Consultee Comments for Planning Application 2025/90453

Application Number: 2025/90453

Address: 46 Stile Common Road, Primrose Hill, Huddersfield, HD4 6DE

Proposal: Erection of 2 dwellings for student accommodation and emergency housing

Drawing: UD-498 Revision:

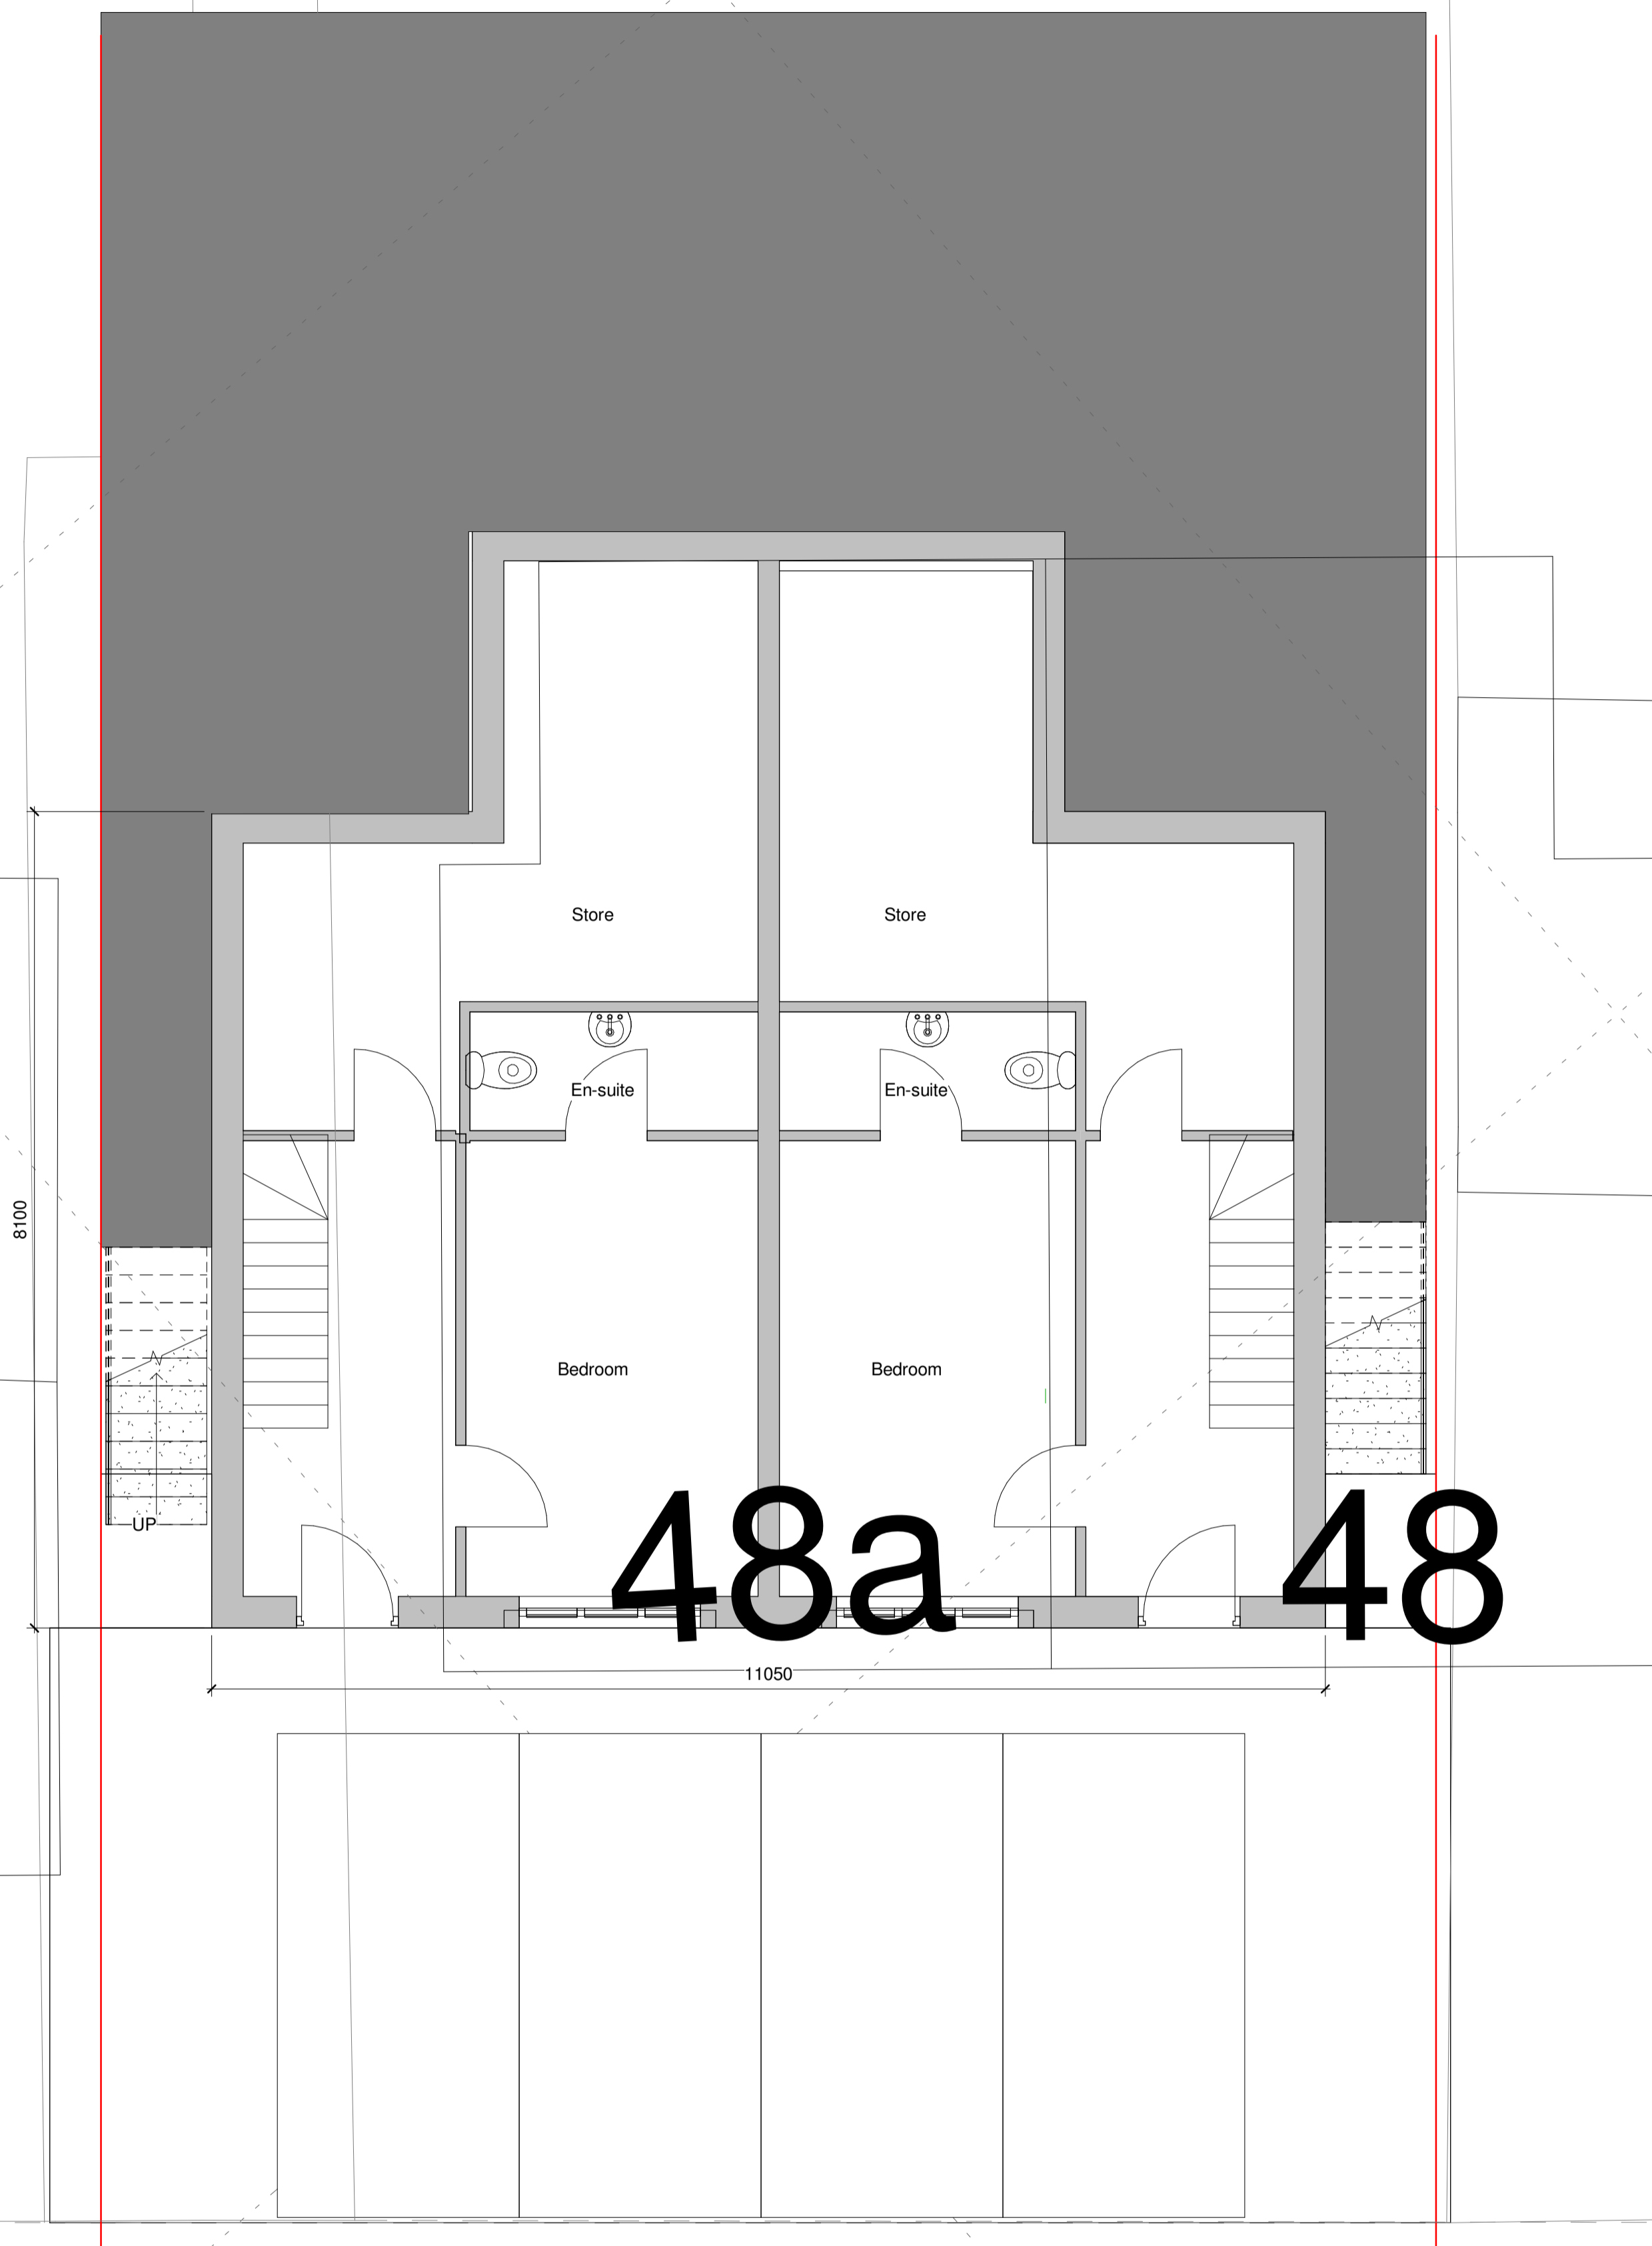
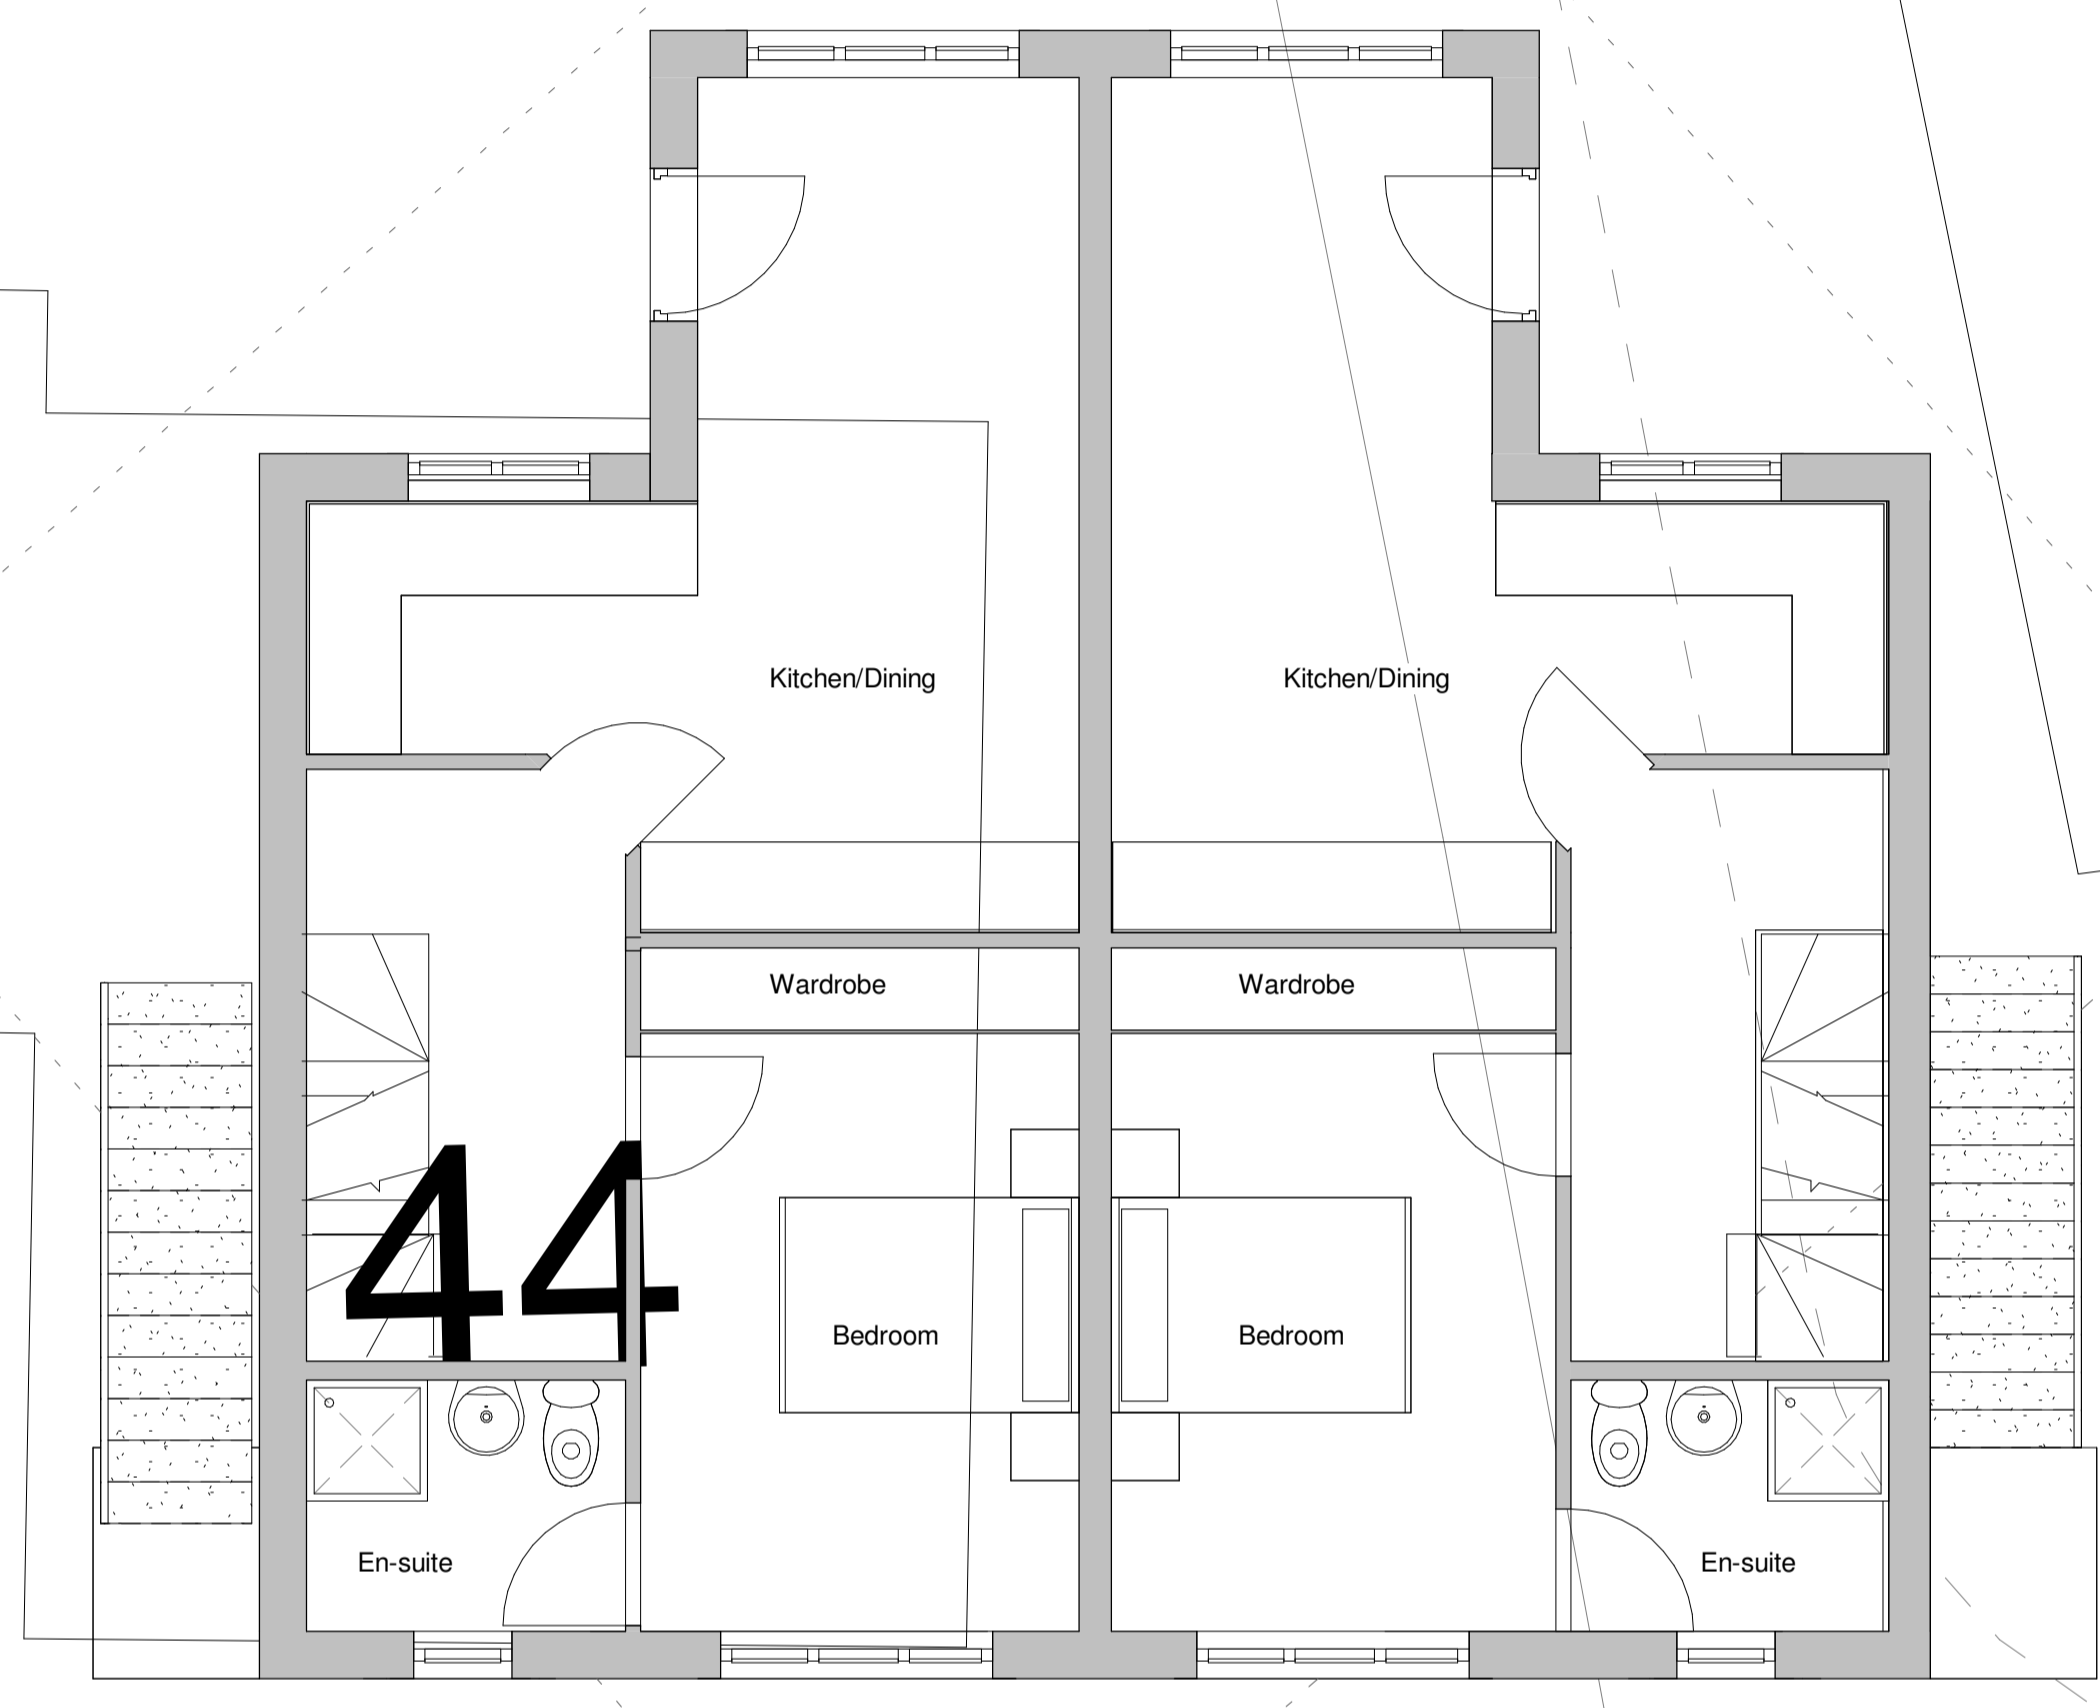
Drawing UD-498 does not show any subdivision lines at the front or rear of the building. Shared front and rear areas are unacceptable should one part of the site be occupied by students and the other by residents requiring emergency housing.
